APPLICATION 2024/62/90932/W
LAND ADJACENT – 4 DOWNING STREET, LINTHWAITE, HUDDERSFIELD HD7 5PU

We are writing on behalf of a local resident to express concerns with regard to the above application for the erection of detached dwelling.

Ground Floor Plan
1 : 100

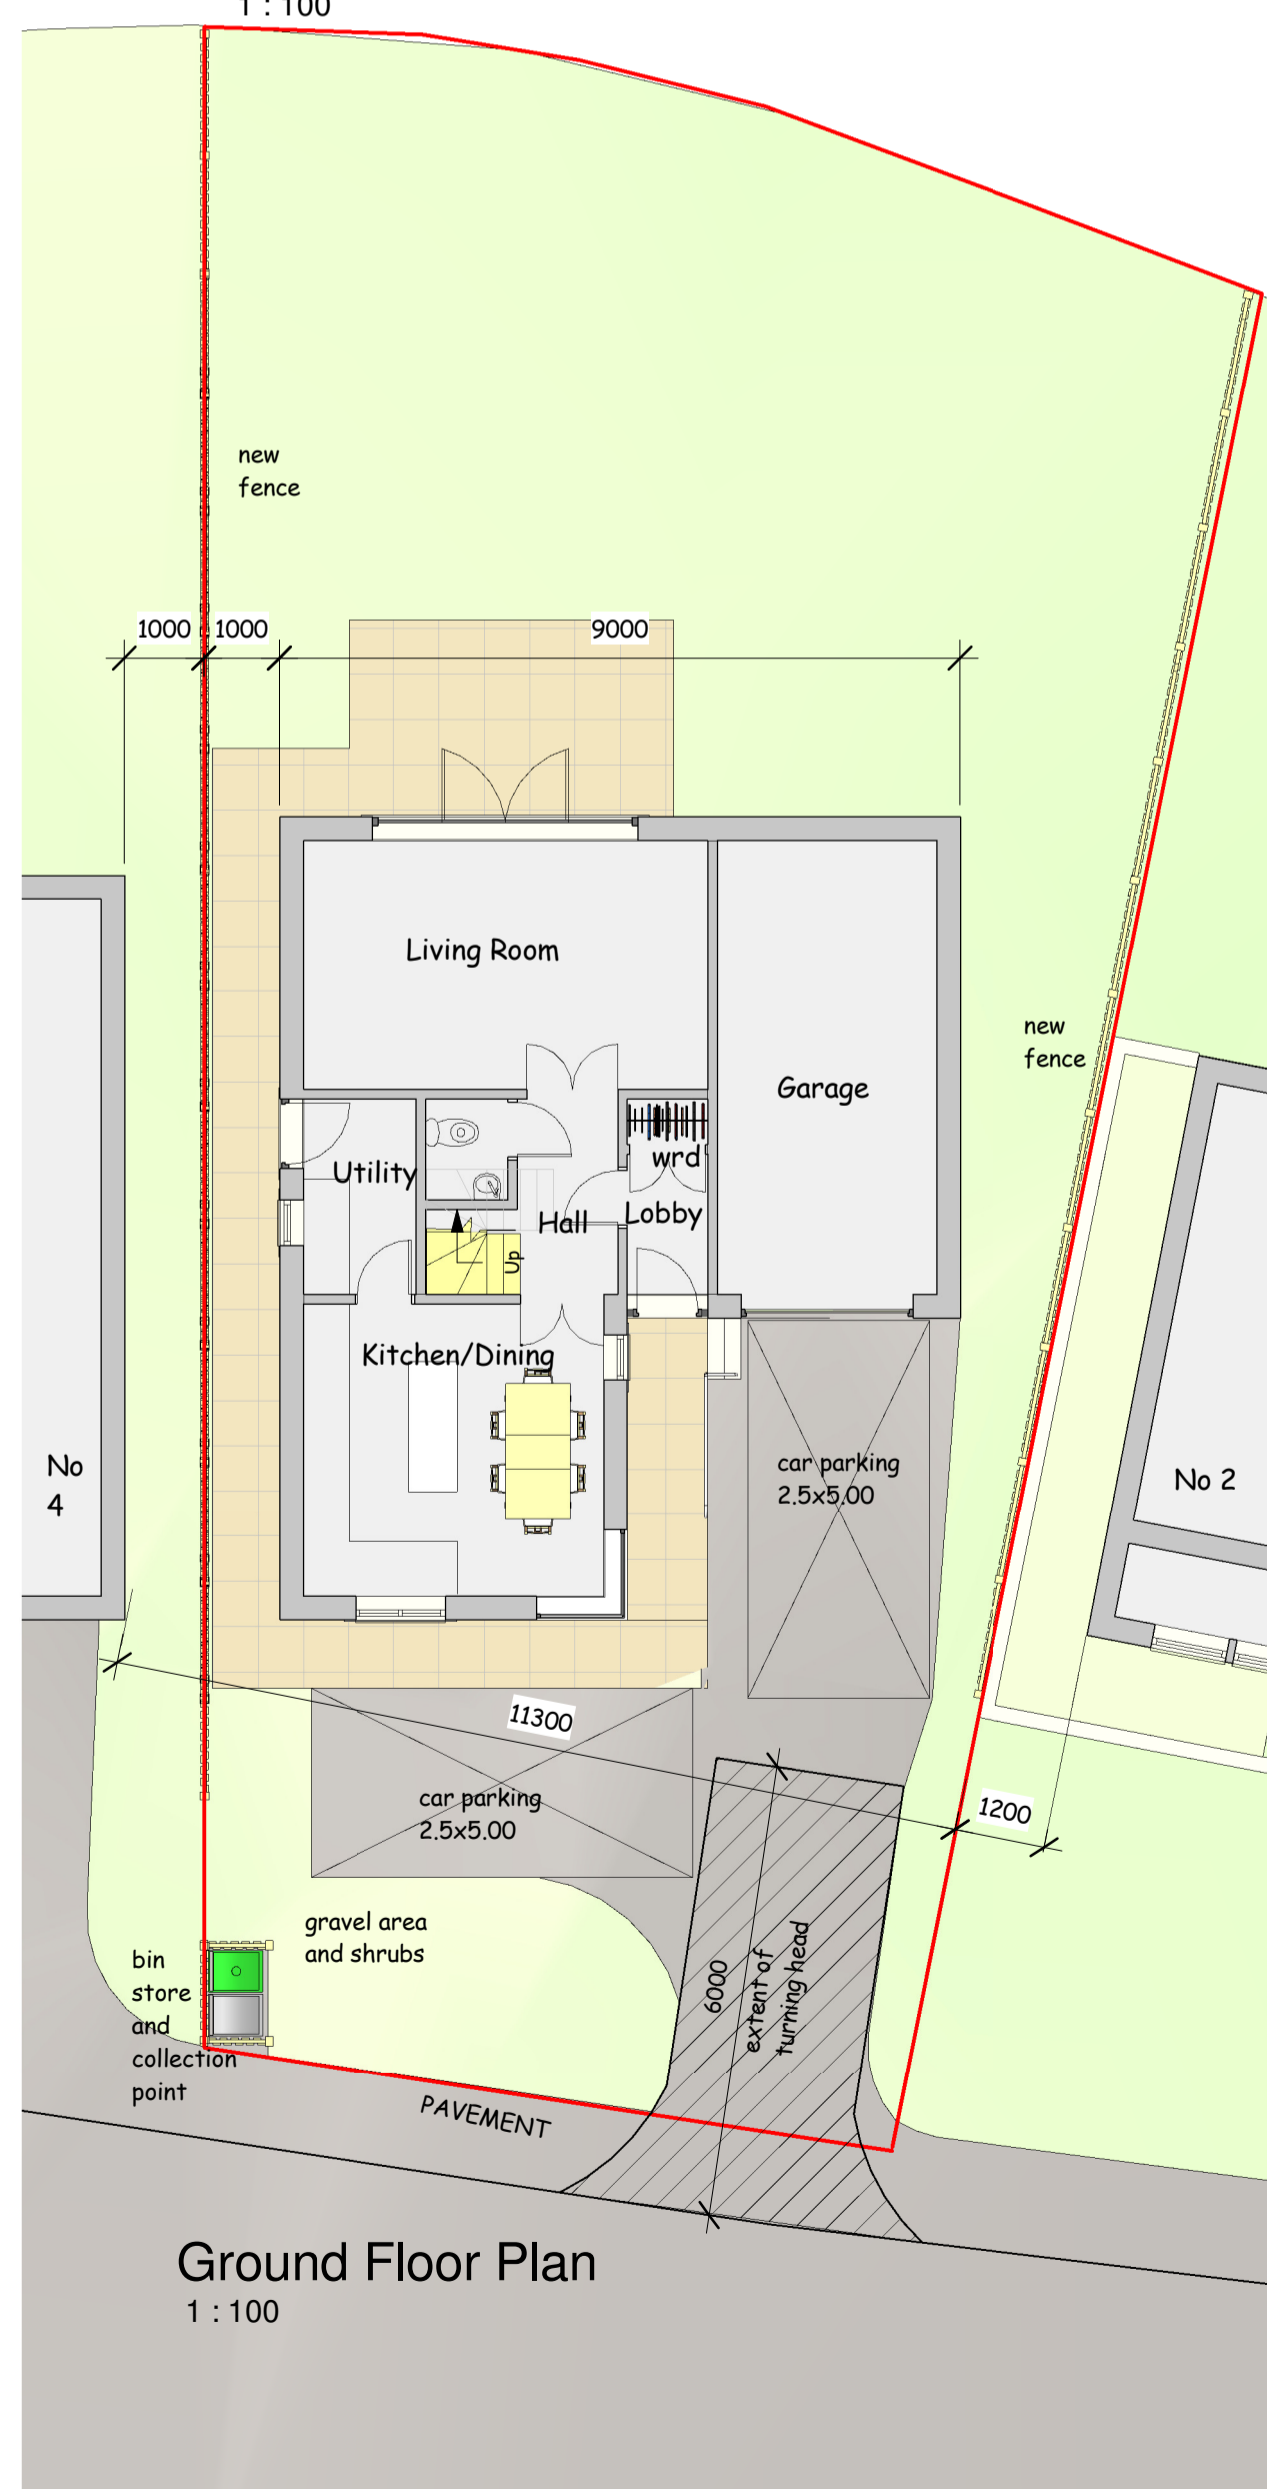
The proposals are again to squeeze a new dwelling in between the gap between Nos. 2 and 4. The current characteristics of Downing Street, which is clearly a semi-rural setting, is for large frontage properties with good sized gaps between. The proposals, by filling in the gap, will appear incongruous, inappropriate and will harm the openness of this setting. This goes against the Kirklees MC Housebuilders Design Guide (SPD), where it clearly states '*New residential development proposals will be expected to respect and enhance the local character*'. The guide also states in 7.19 '*...for a new dwelling located in a regular street pattern that is two storeys or above, there should normally be a minimum of a **2 metres** distance from the side wall of the new dwelling to a shared boundary*'. From the plans this distance has not been achieved. Indeed the distance indicated is half that recommended, with 1.0m shown to the shared boundary to No. 4 on both sides.

Block Plan
1 : 500

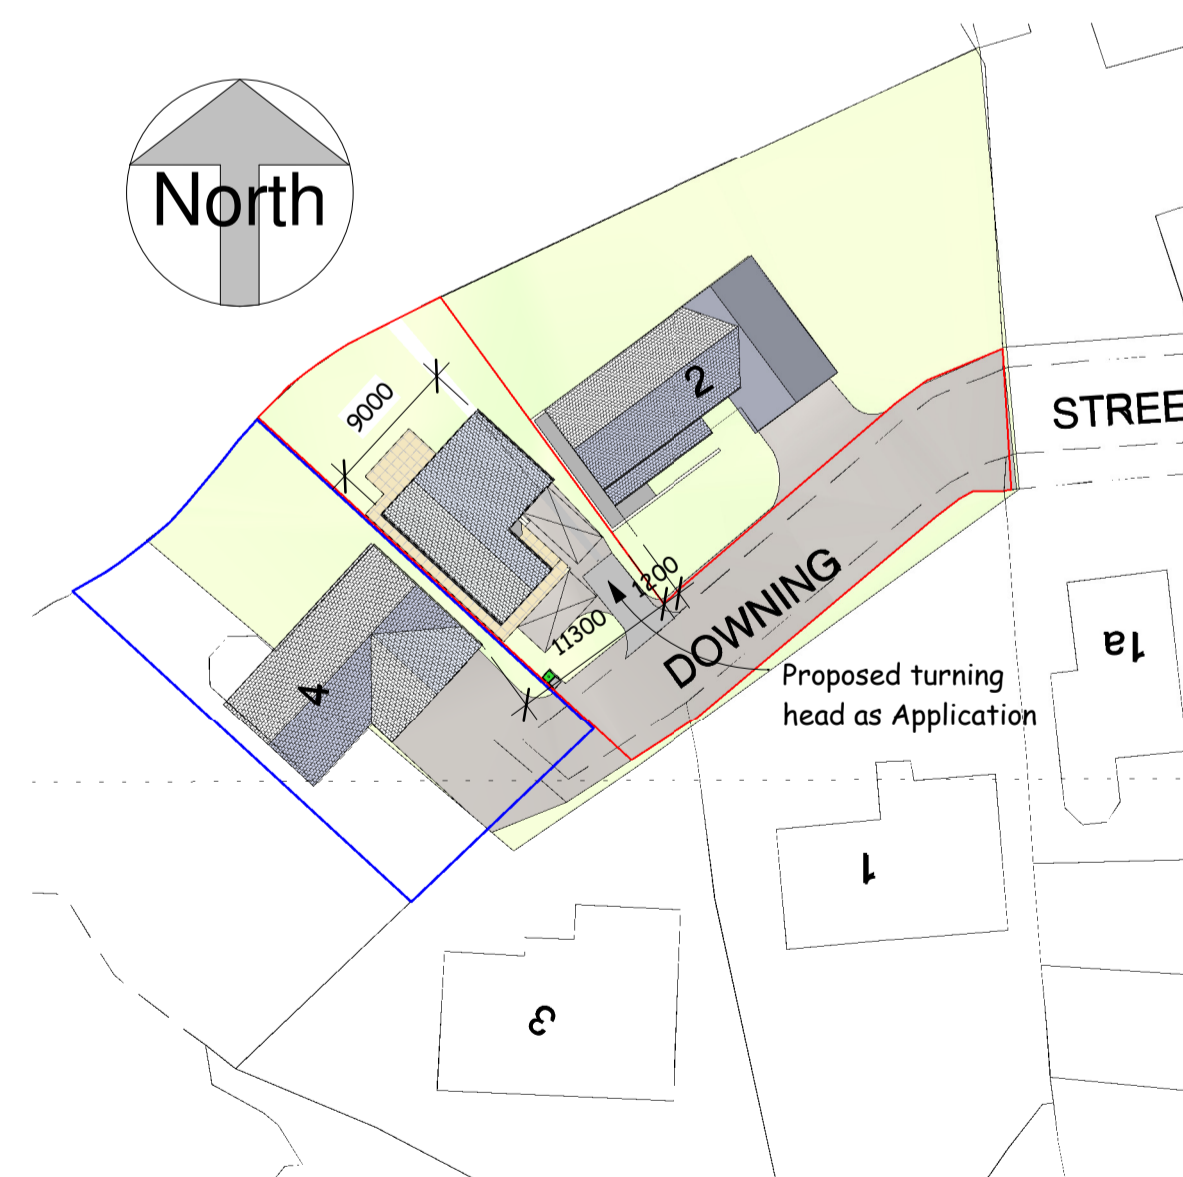
The proposed dwelling is South West of the neighbouring property at No. 2. This will inevitably cause significant shadowing to that property and in particular the rear garden which is the main amenity to that dwelling. The overshadowing will be exacerbated by the fact that the proposed dwelling will sit higher than the neighbouring house and further back into the site. This is clear from the Block Plan provided on the application drawings.
